Recommendation Report for Planning Permission for Works or Extension to a Dwelling**REF NO:** R/168/14/HH**LOCATION:** 7 Cross Road
Rustington**PROPOSAL:** Single and two storey extensions (resubmission following R/20/14/)**SITE AND SURROUNDINGS****DESCRIPTION OF APPLICATION**

**Drg No:** 1279/14/P/01

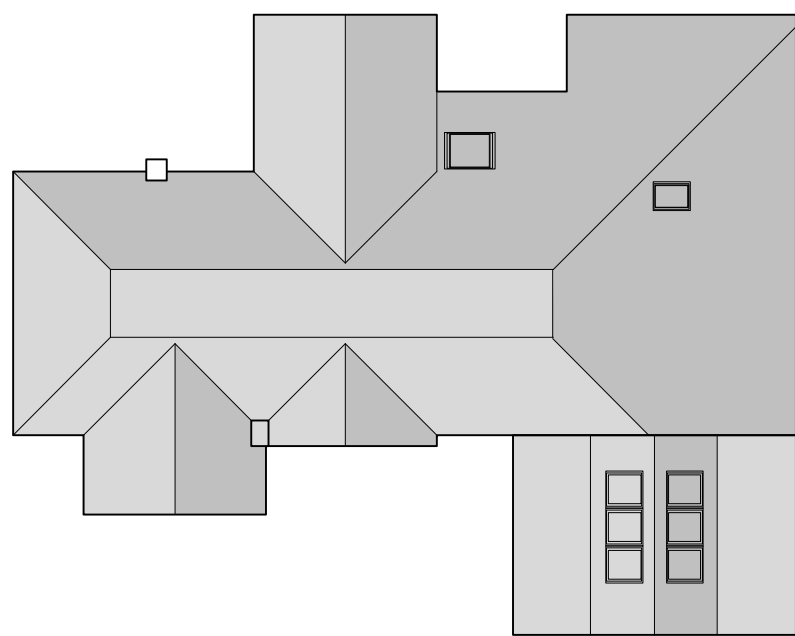
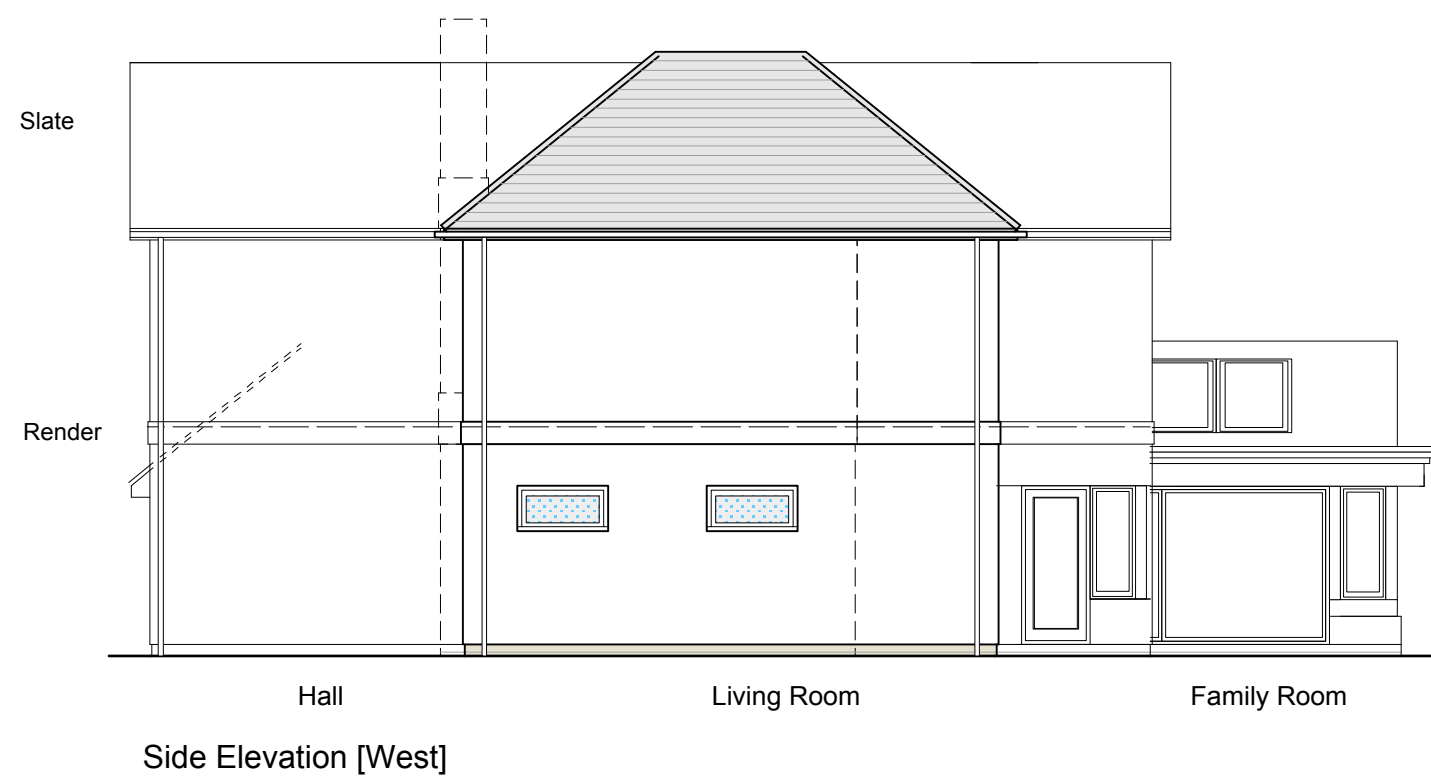
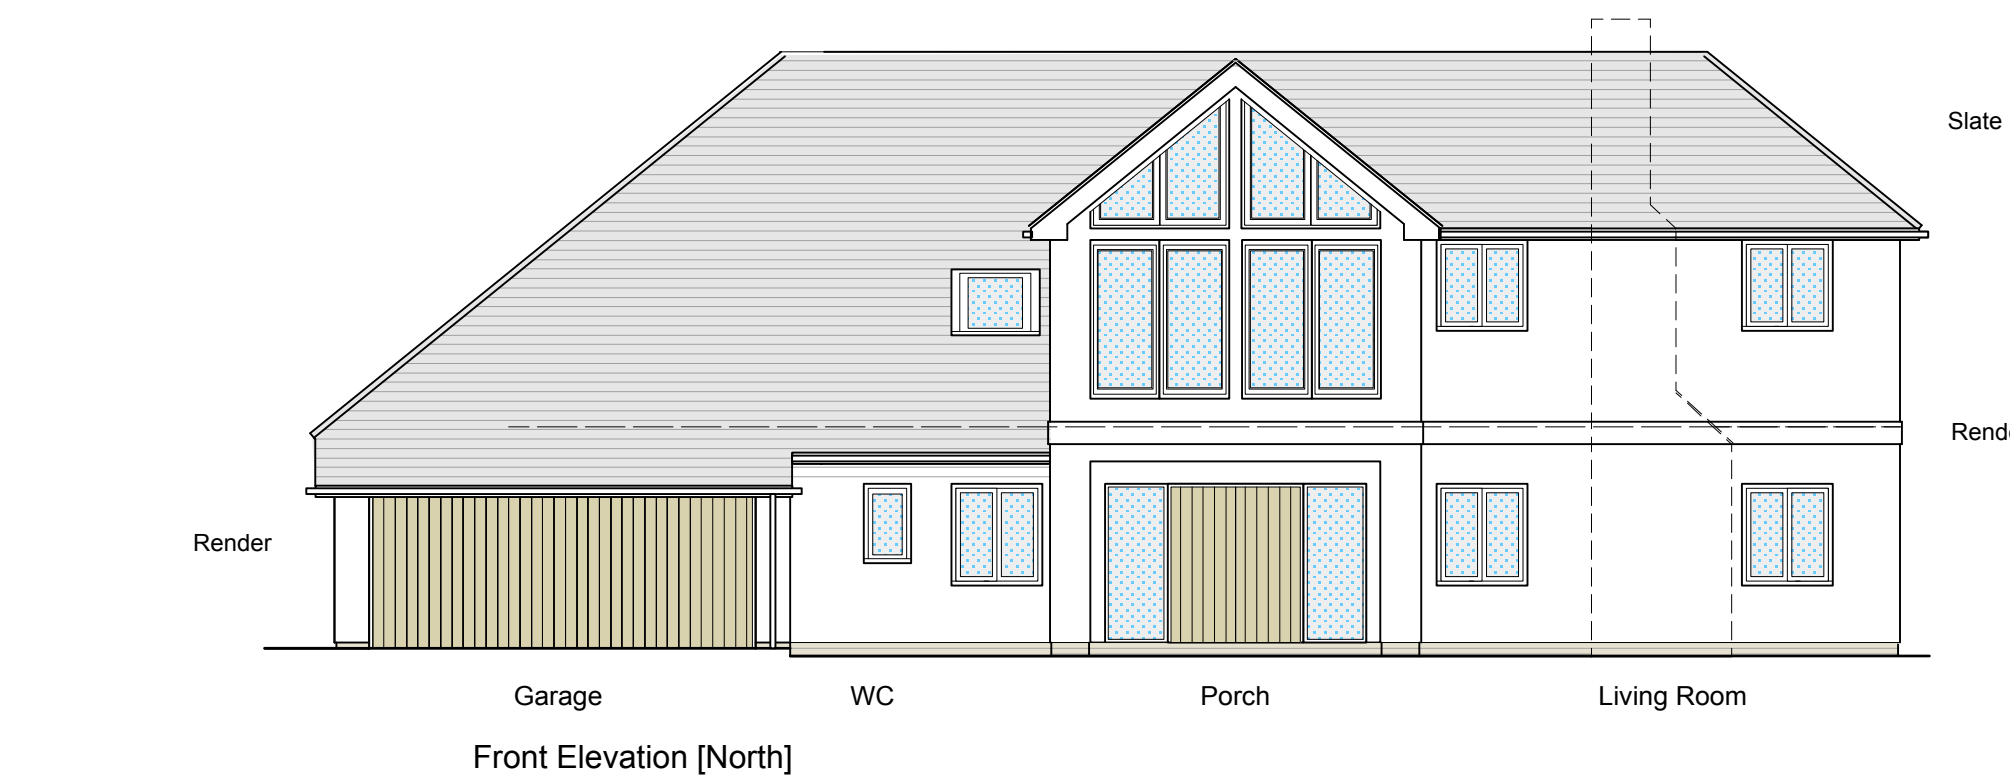
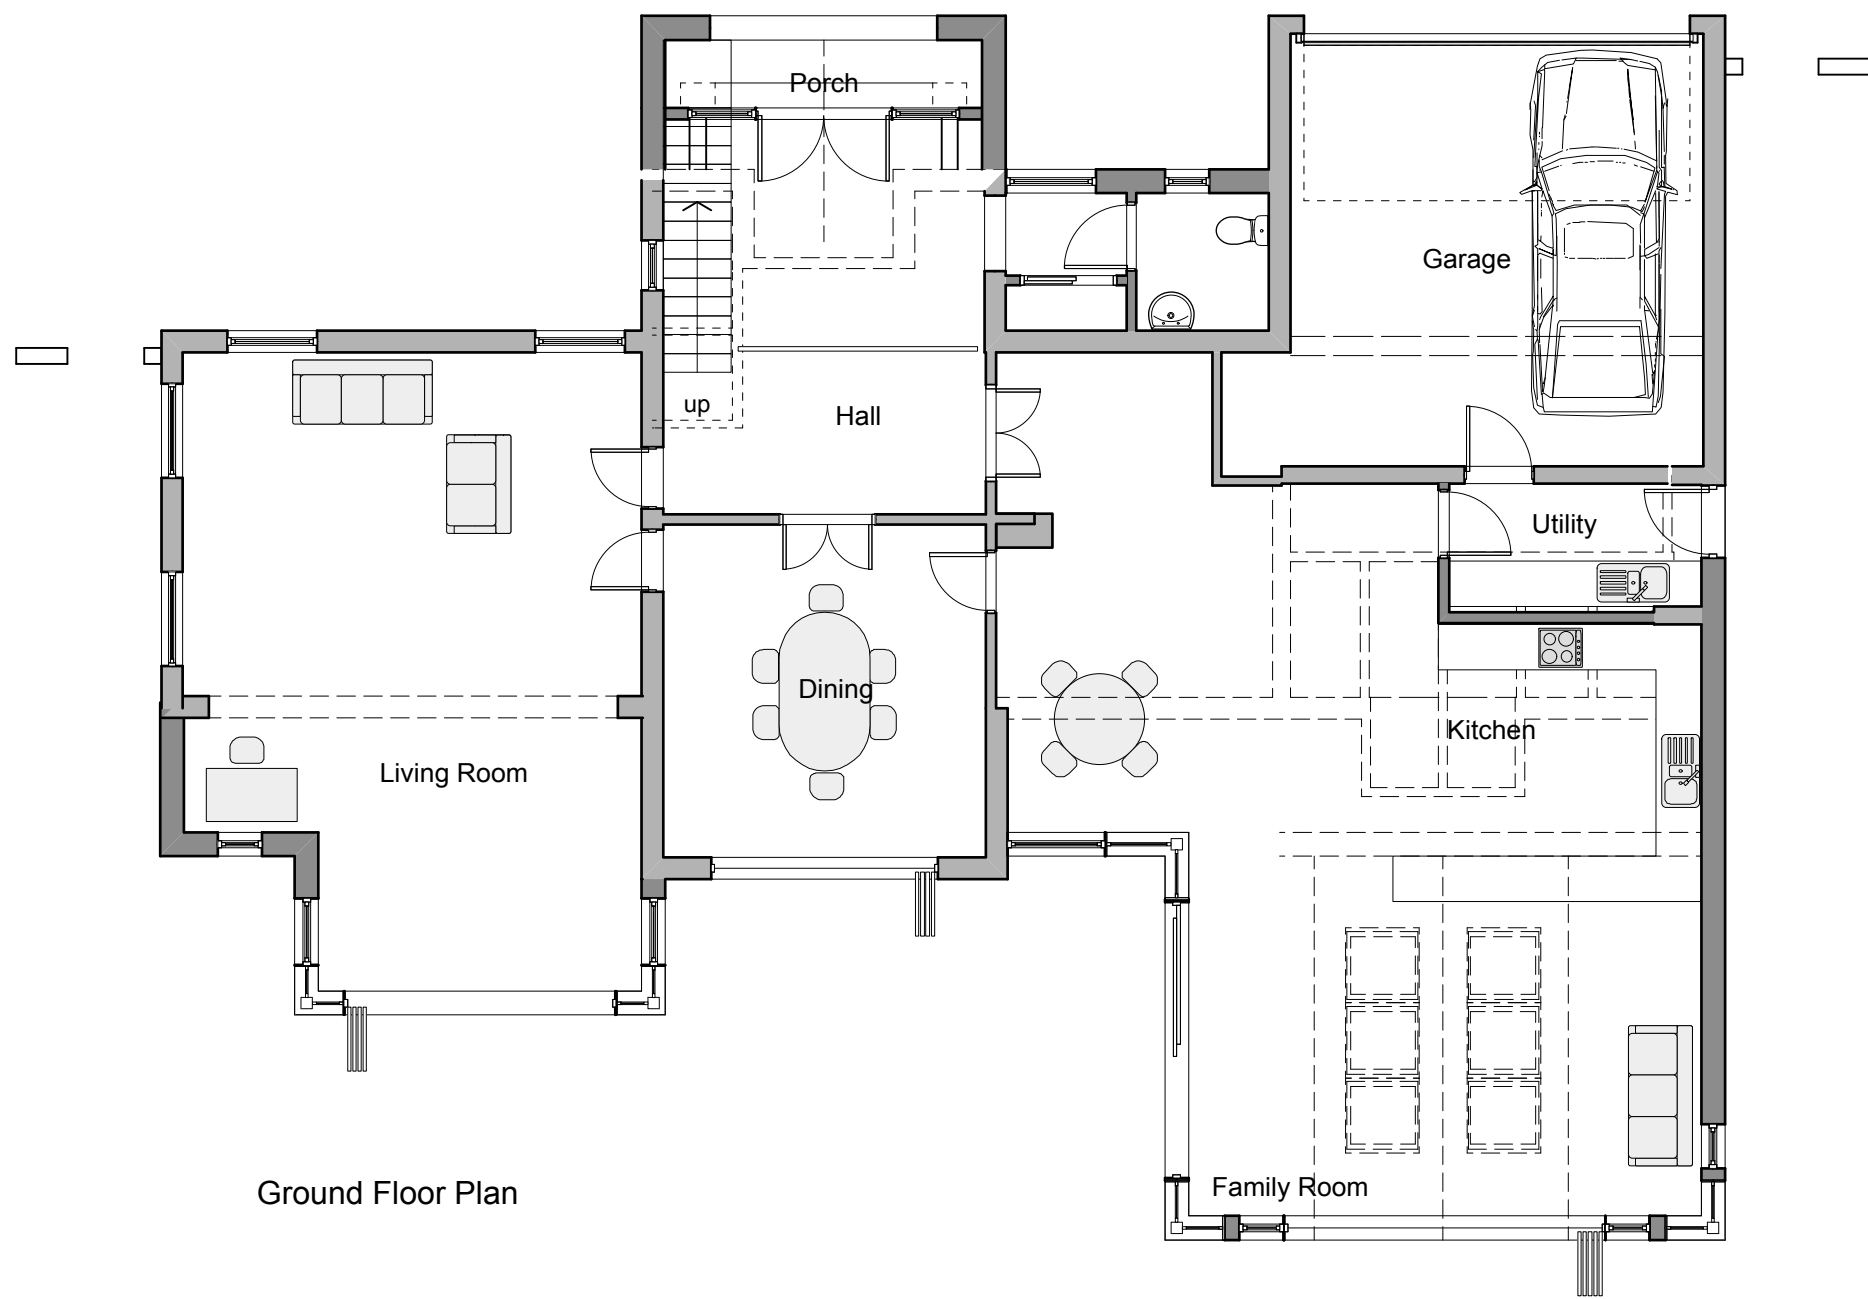
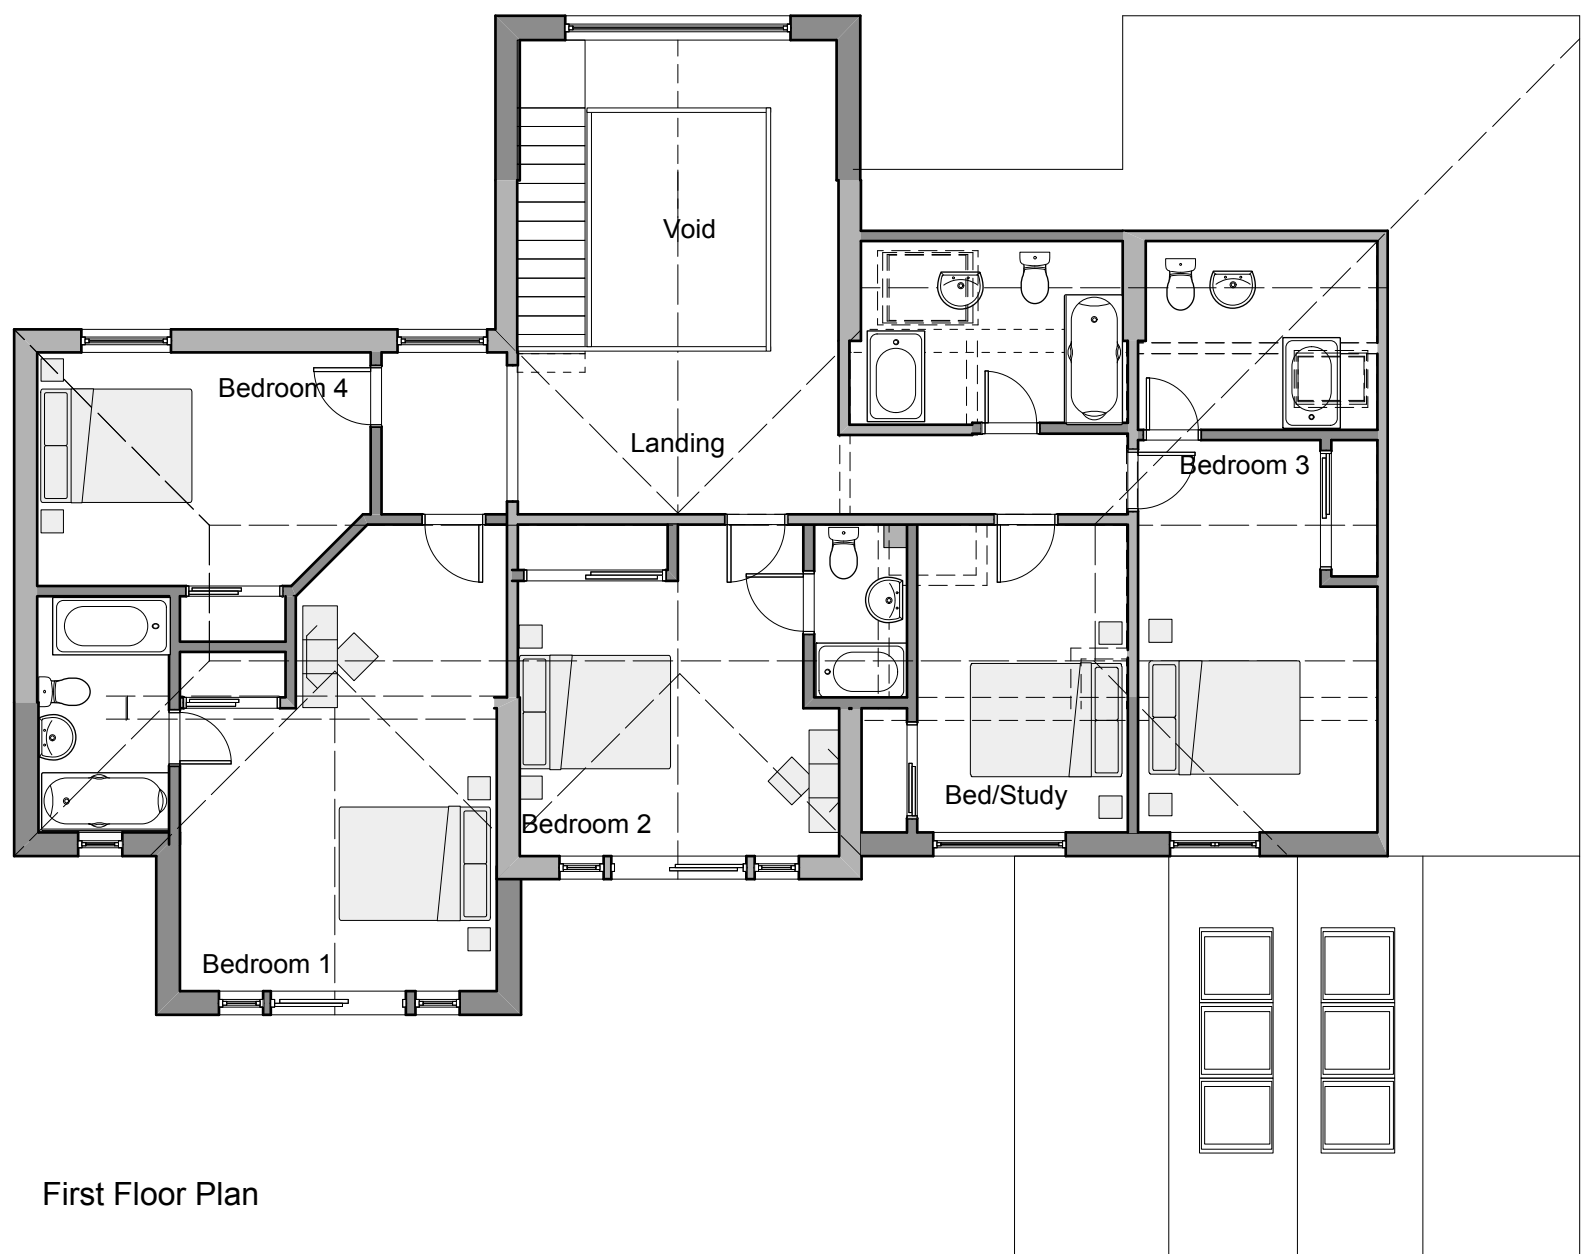
One letter of objection - the plan shows a freefall outside the full length windows of bedrooms 1 and 2. It is assumed there would be safety bars in front, but should these become balconies they would look directly into the large West facing complex of neighbour's main living area and adjoining patio areas. It is requested a condition is imposed preventing the building of such balconies. Any overlooking would be totally unacceptable. The windows in the roof of the extension forming the family room are forward of and immediately below neighbour's window and are potentially the source of disturbing light and noise at night. To reduce this a condition requiring non opening and opaque glazing on the east side is requested. The bathroom window in bedroom 3 facing east would look directly into neighbour's west facing windows. Could this window be relocated?

- 4 The window in the east elevation of the roof shall at all times be glazed with obscured glass.

- 5 No windows (other than those shown on the plans hereby approved) shall be constructed at first floor level or in the roof in the east elevation of the extension hereby permitted which adjoins the side boundary with 5 Cross Road without the prior permission of the Local Planning Authority on an application in that behalf.

Any balcony would require the submission of an application for planning permission which would be considered on its own merits. The application can only be considered in relation to what is proposed and it would not be reasonable to impose a condition preventing a structure that would require permission in its own right. The east side of the ground floor extension is mainly brickwork and only the central portion of the roof is glazed. It is not considered that light spill or noise from the family room would adversely affect the residential amenities of neighbouring properties. The levels would not exceed those usually generated by a family home. The proposal as submitted would not result in any materially adverse direct overlooking of the adjoining dwelling. The roof light in the east roof slope would serve a bathroom and would be high level. It is not therefore considered that it would result in materially adverse overlooking or loss of privacy to the adjoining property 5 Cross Road. A condition is imposed relating to obscure glazing, but it is considered that it would be unreasonable to require it to be non-opening given the use of the room and the position and obscure glazing to windows on the side elevation of the adjacent property.
